# **KITTITAS COUNTY**

## **DEPARTMENT OF PUBLIC WORKS**

**TO:** All Staff  
**FROM:** Public Works Plan Review Team  
**DATE:** August 7, 2024  
**SUBJECT:** BL-24-00014 McKeown

CRUSE & ASSOCIATES
 PROFESSIONAL LAND SURVEYORS
 217 East Fourth Street
 P.O. Box 959
 Ellensburg, WA 98926 (509) 962-8242
 MCKEOWN PROPERTY

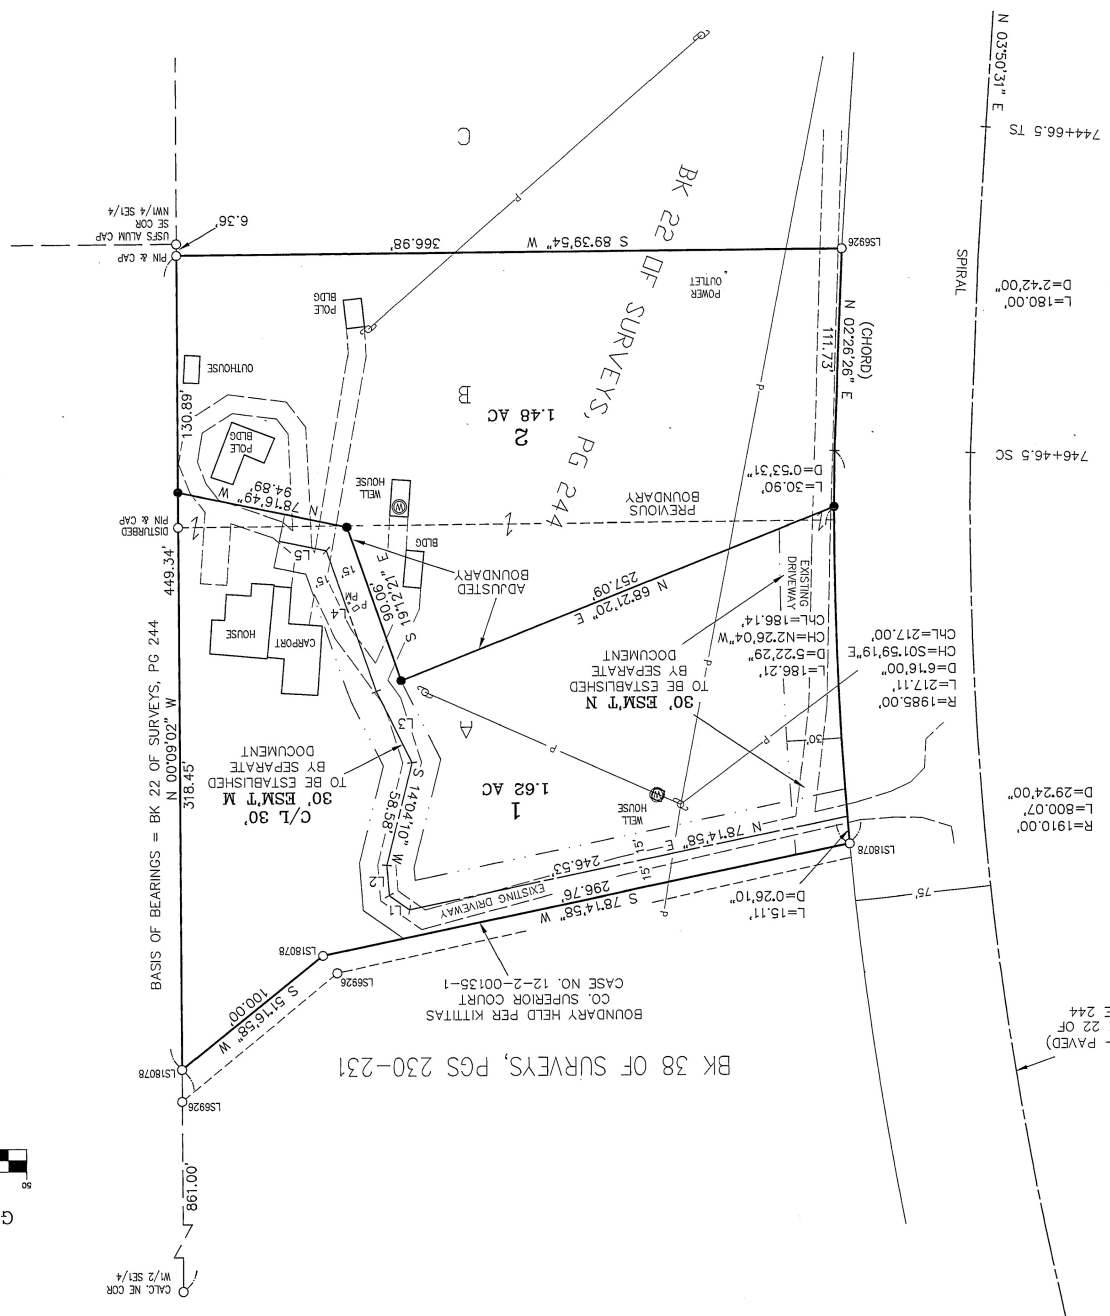
<b>SURVEY</b>	<p>As the application does not contain a survey map, comments are herein reserved until final. (JT)</p> <p>Update 10/10/24 – SR97 needs to show ownership and Row. Centerline and bearings also needs to be called out. Recording number for new easement is missing.</p>
<b>TRANSPORTATION CONCURRENCY</b>	No transportation concurrency requirement for this project. (KAH)
<b>FLOOD</b>	Parcels 075335 and 085335 are not located in a FEMA identified special flood hazard area (100-year floodplain). A floodplain development permit is not required. (SC)
<b>WATER MITIGATION/ METERING</b>	No comments. (SC)
